# **Sydney Football Stadium Redevelopment Concept and Stage 1 Works – Modification 6 – Inclusion of Precinct and Carpark Building Envelope.**

## **Application SSD-9249-Mod 6**

Submission by Andrew Andersons AO, Architect  
andrewpaddo@gmail.com  
0427 609 907

**Figure 7 |** Comparison of the proposed Precinct Village and carpark building envelope shown in blue and stadium envelope and surrounding administration buildings shown in grey (Source: Modification 6 Architectural Plans)

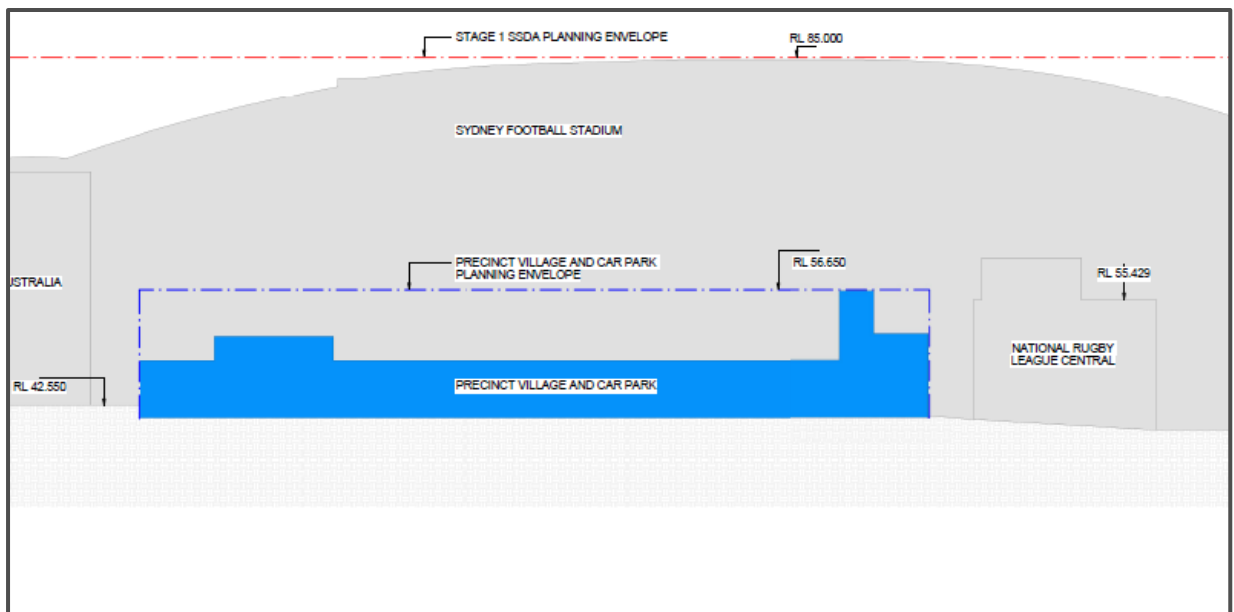
East West section A1 included in the exhibited drawings shows what appears to be a significant above-ground projection of the building envelope on the Driver Avenue alignment. To preserve the “parklike appearance” of the site, it is essential that perimeter trees be maintained and if the car park is to project above the level of Driver Avenue, a suitable landscape transition is constructed.

*It is unclear where this section is drawn but it would be unfortunate if the 'below ground' parking were to project above the level of Driver Avenue without a gentle landscaped transition.*
